From: Nicola Swann [REDACTED]
Sent: 28 July 2022 13:44
To: Planning.Responses <Planning.Responses@arun.gov.uk>
Subject: Pagham responses

At a meeting of its Planning Committee held on 26th July 2022, Pagham Parish Council considered the following applications:

P/96/22/HH. 97 Harbour View Road Pagham PO21 4RJ. Erection of single storey outbuilding to rear.

Block Plan shows area bounded by: 489009.02, 97733.32 489099.02, 97823.32 (at a scale of 1:500), OSGridRef: SZ89059777. The representation of a road, track or path is no evidence of a right of way. The representation of features as lines is no evidence of a property boundary.

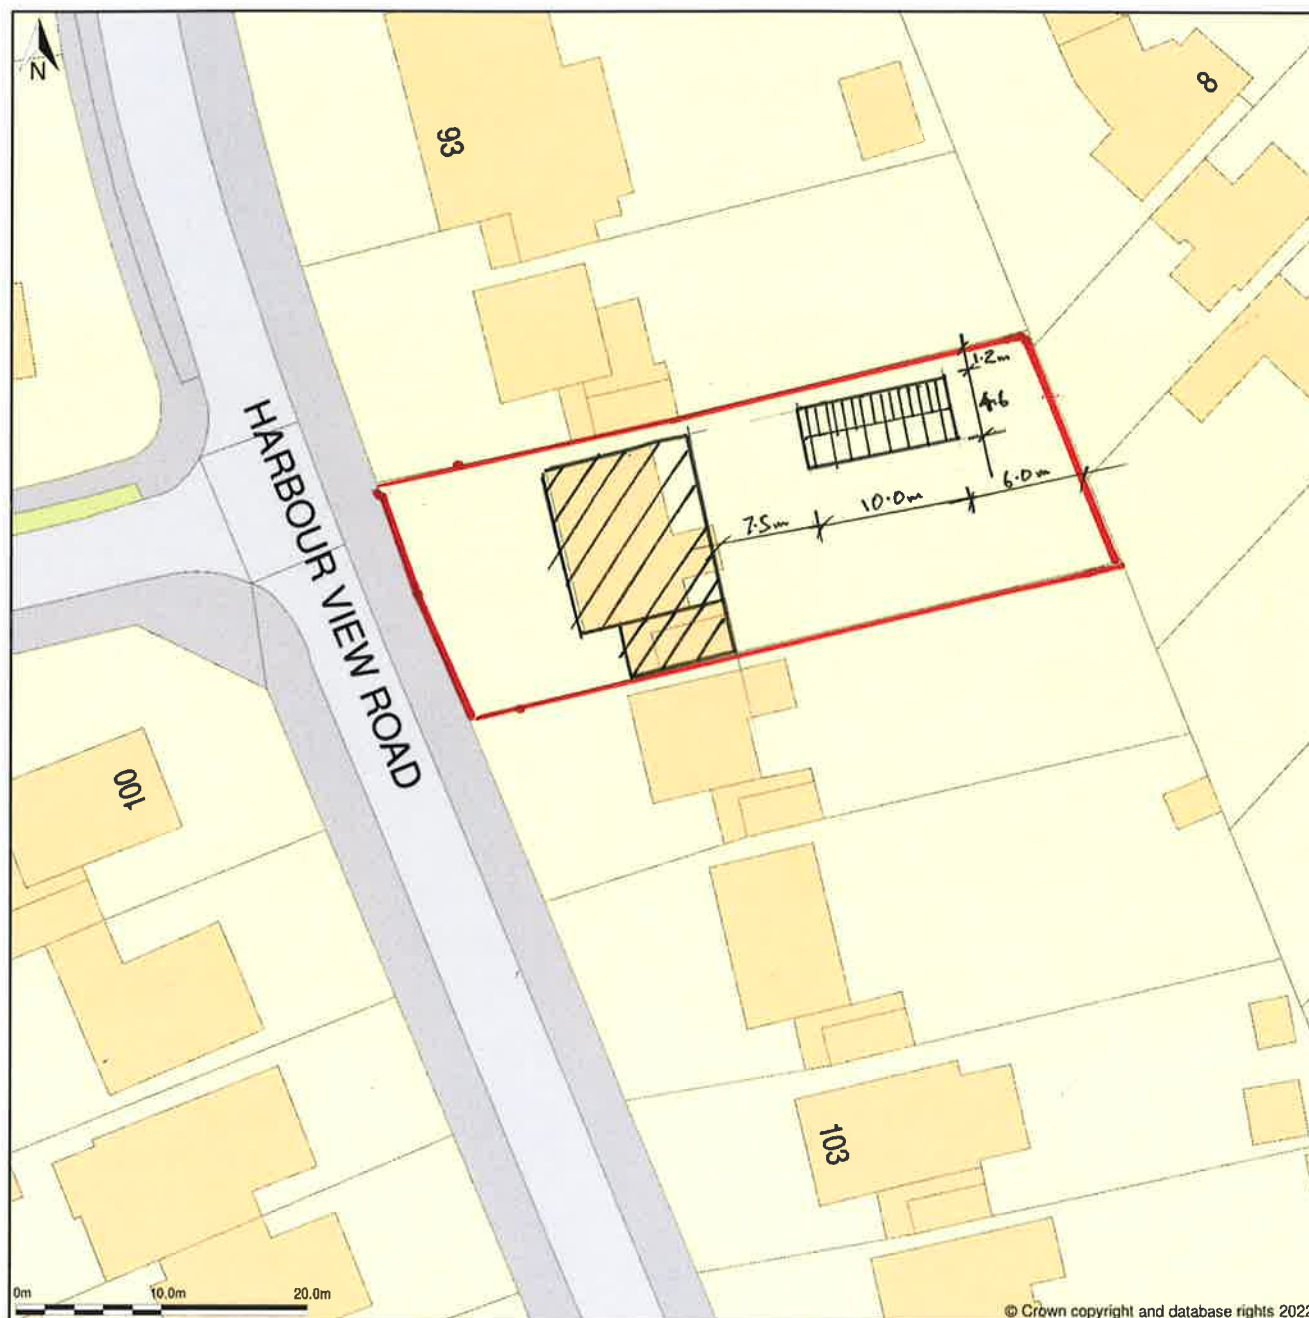
problems with overshadowing for neighbouring properties. The Council had been invited to the garden of a neighbouring property and had seen that the building had commenced but not in the orientation suggested on the plans. It is recommended that a site visit take place. The building was also taking place too near the boundary of the property.

ALL AS PROPOSED.
1:100.

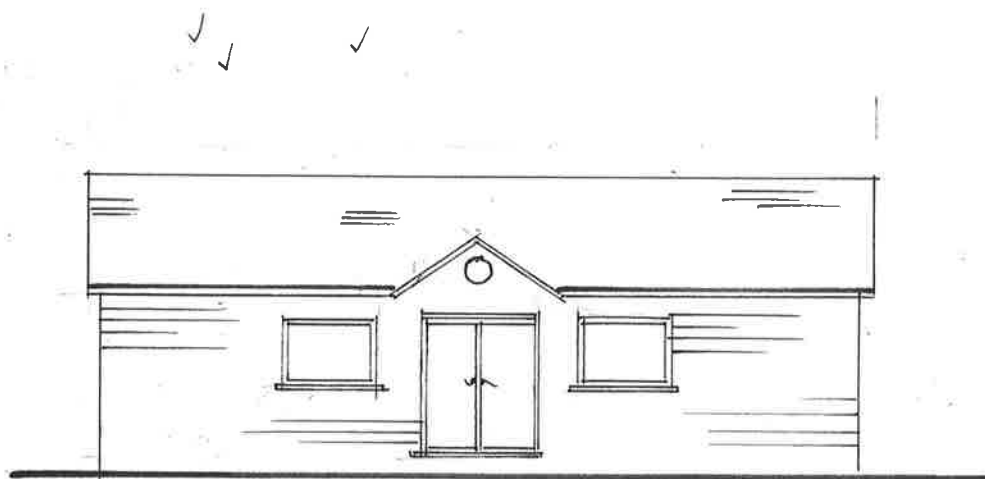
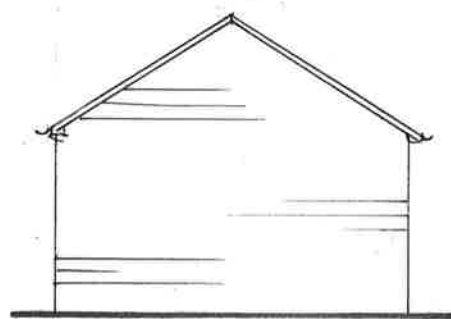
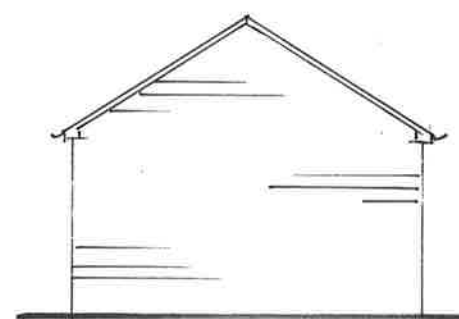
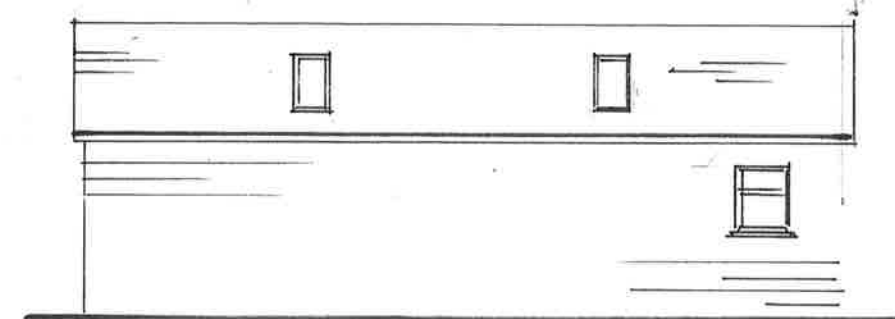
RESOLVED: OBJECT. The Council was concerned that there was no height specified on the plans. It was likely that, given the scope of the building, there would be overlooking issues and
